Please ask for: Ms Iqraa Malik
Email: iqraa.malik@terraquest.co.uk
Telephone: 01212341390
Our Ref: M/115/21/HH
Your Ref:
Date: 16th August 2021

Application for Planning Permission for Works or Extension to a Dwelling

Development: single storey rear extension
Location: 1 Sea Close Elmer Middleton-On-Sea PO22 7RU

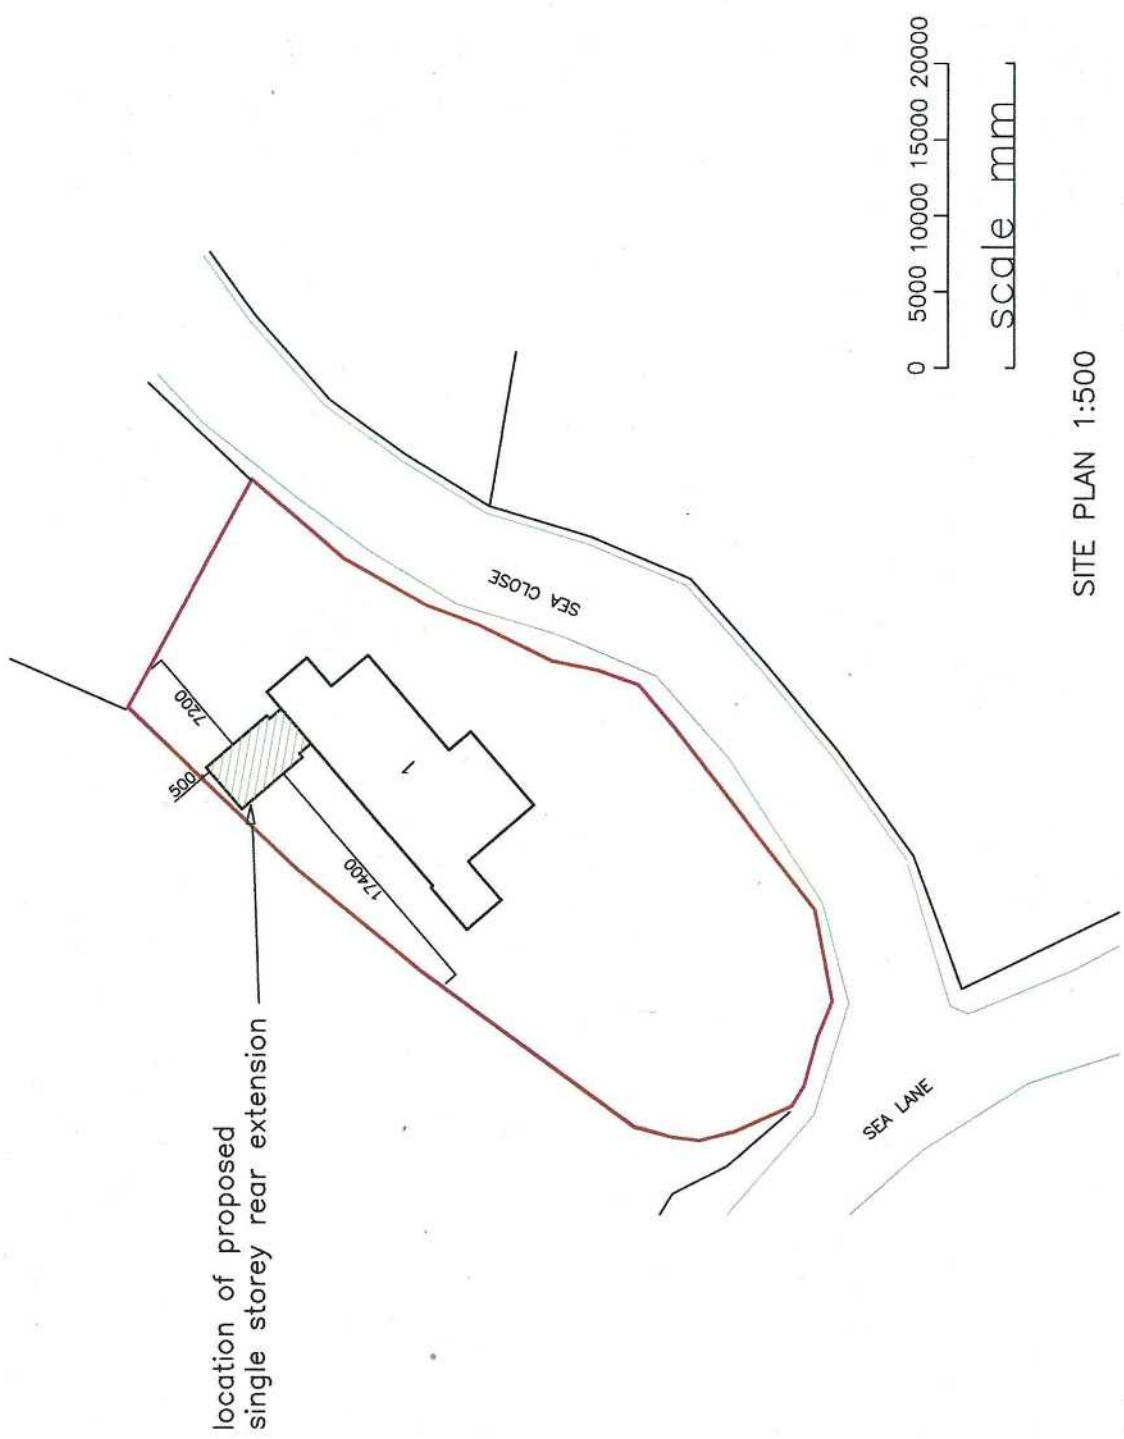
Scale Bar: The scale bar on the location/block plan is not measuring to scale. Please amend.
